Arun District Council
Arun Civic Centre
Maltravers Road
Littlehampton
West Sussex BN17 5LF
Planning & Building Control General Enquiries
Tel: (01903) 737756 Fax: (01903) 730442
Dx: 57406 Littlehampton
Minicom: 01903 732765
e-mail: planning@arun.gov.uk
website: www.arun.gov.uk/planning

Application No: FP/84/22/PL
Site Address: 7 Ambleside Close Felpham PO22 8NG
Description of works: Erection of 1 No three-bed detached dwelling (resubmission of FP/86/21/PL). This site is in CIL Zone 4 and is CIL Liable as a new dwelling.

Felpham Parish Council object to this application on the following grounds:

PROPOSED SITE PLAN
SCALE: 1:100 @ A1

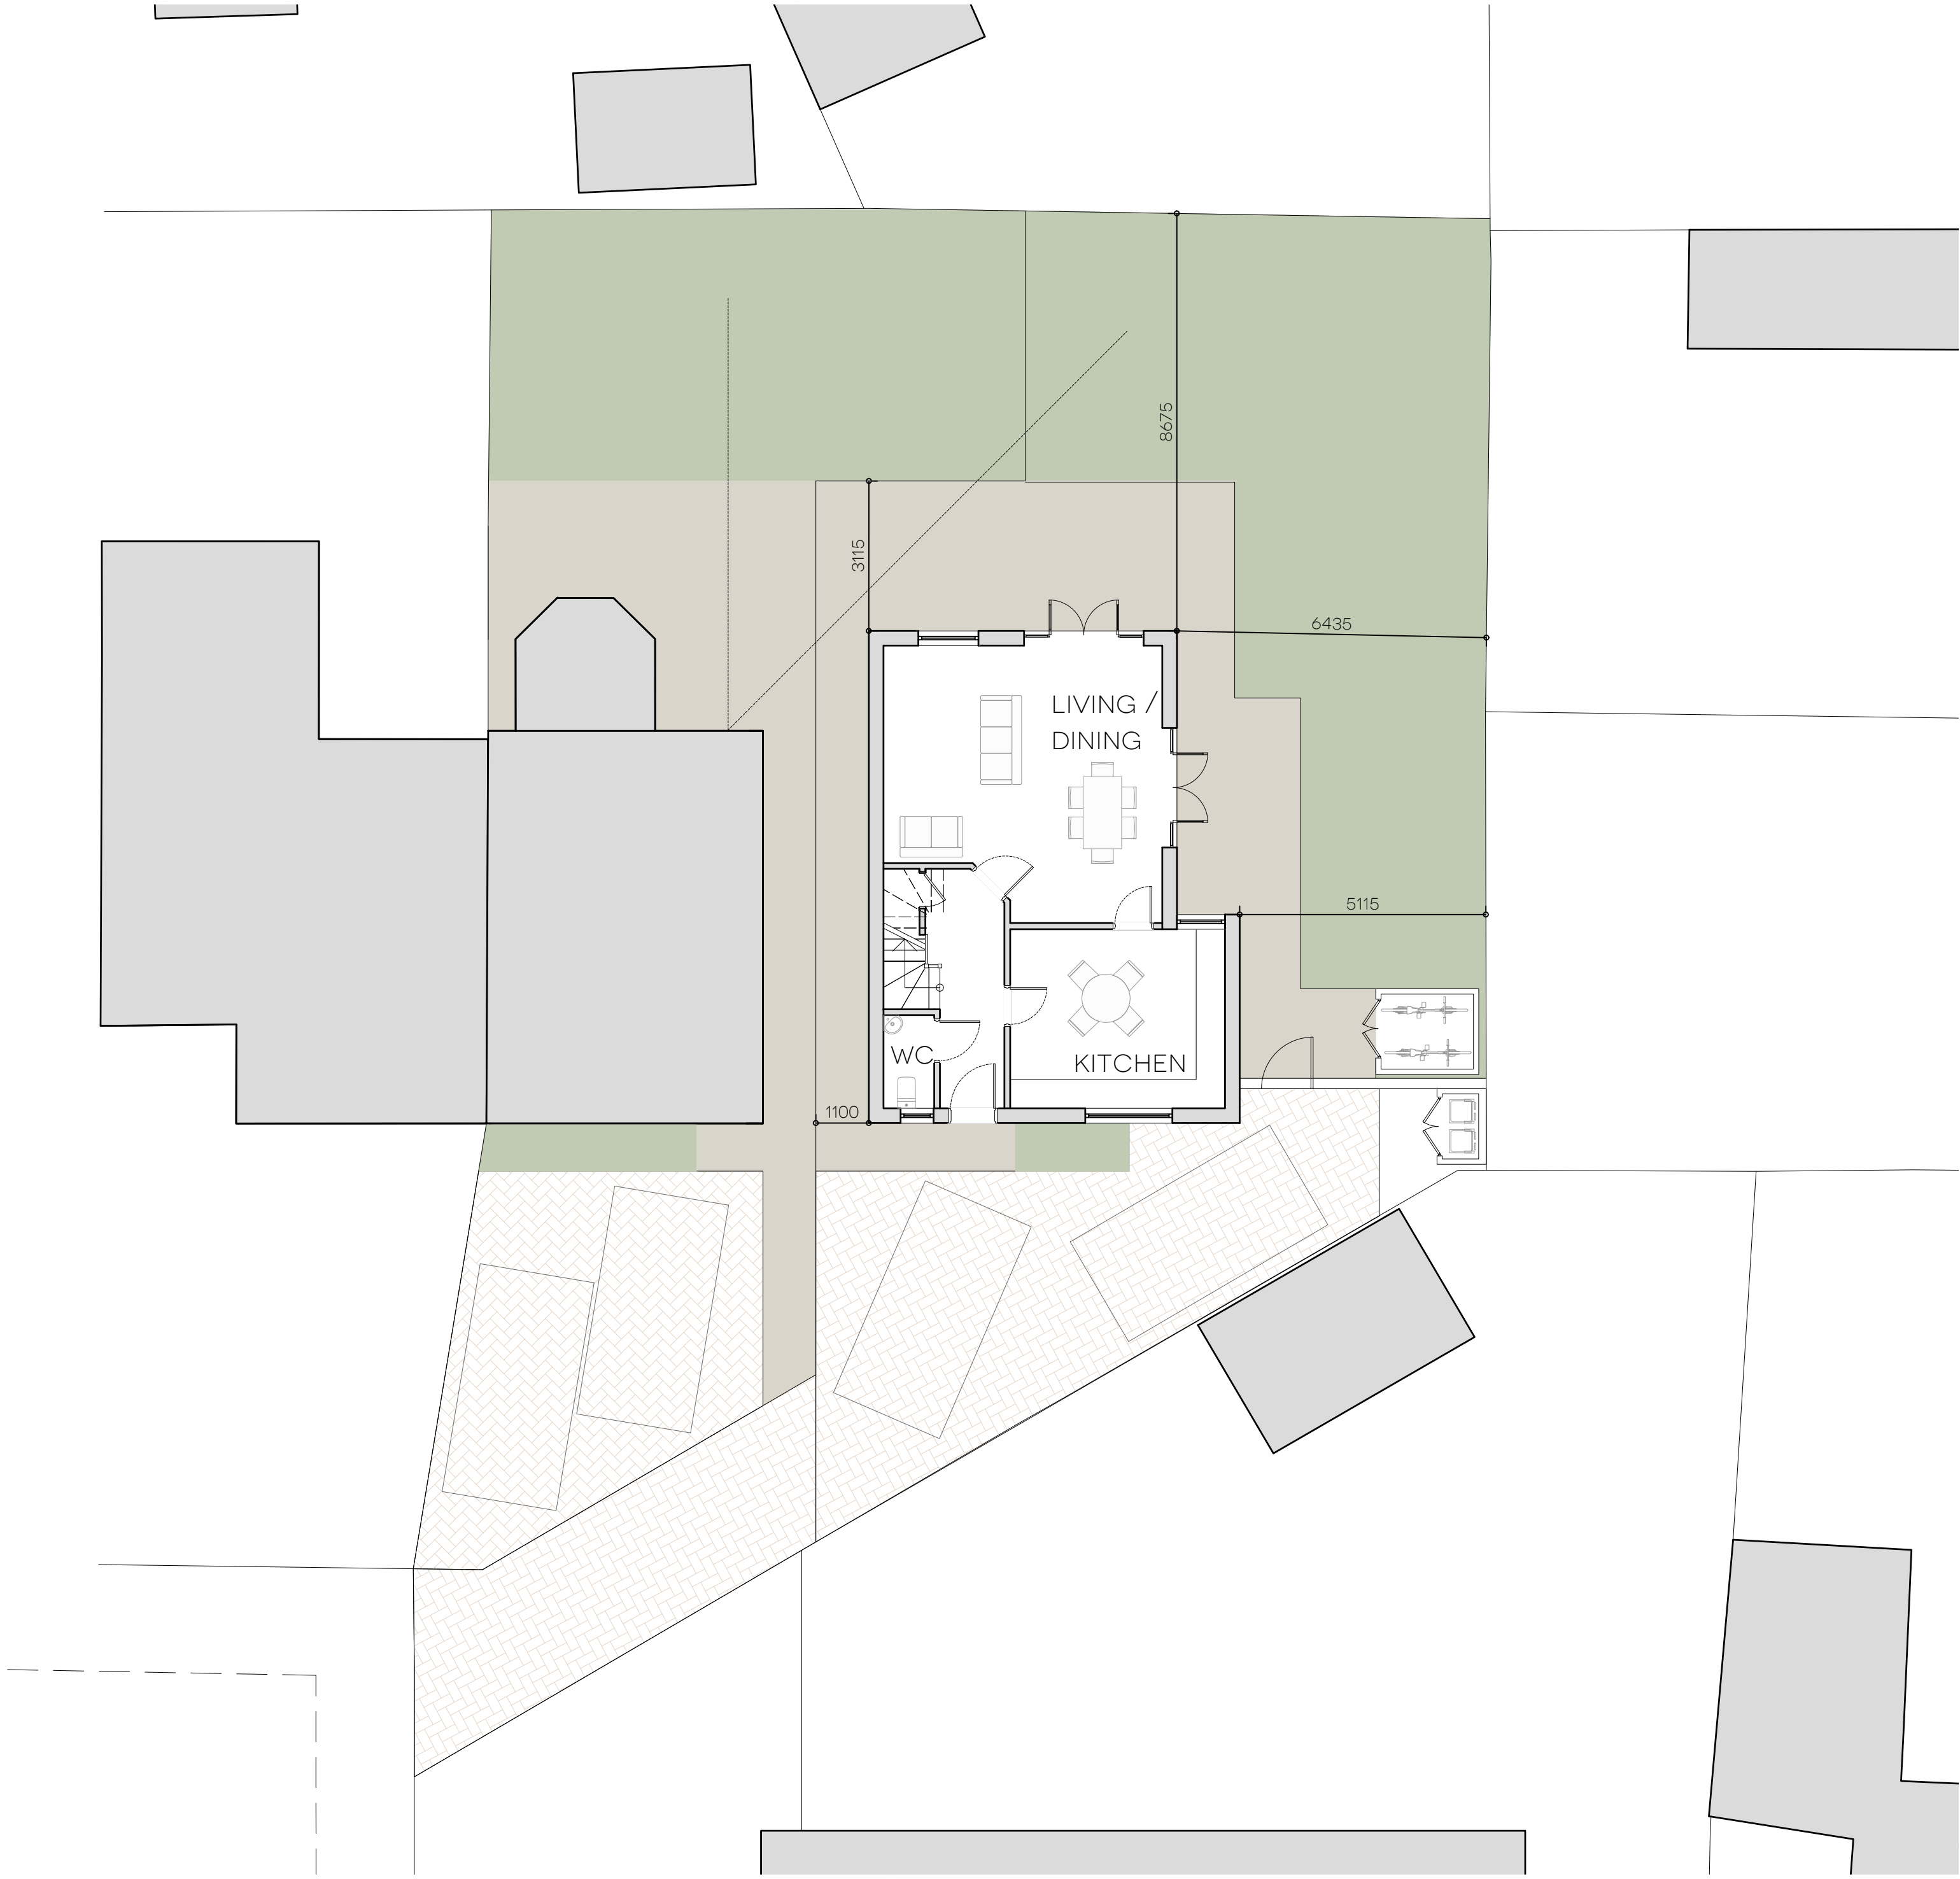
No adequate turning circle for vehicles meaning that they will have to reverse onto the road. This problem has still not been addressed as per previous applications.
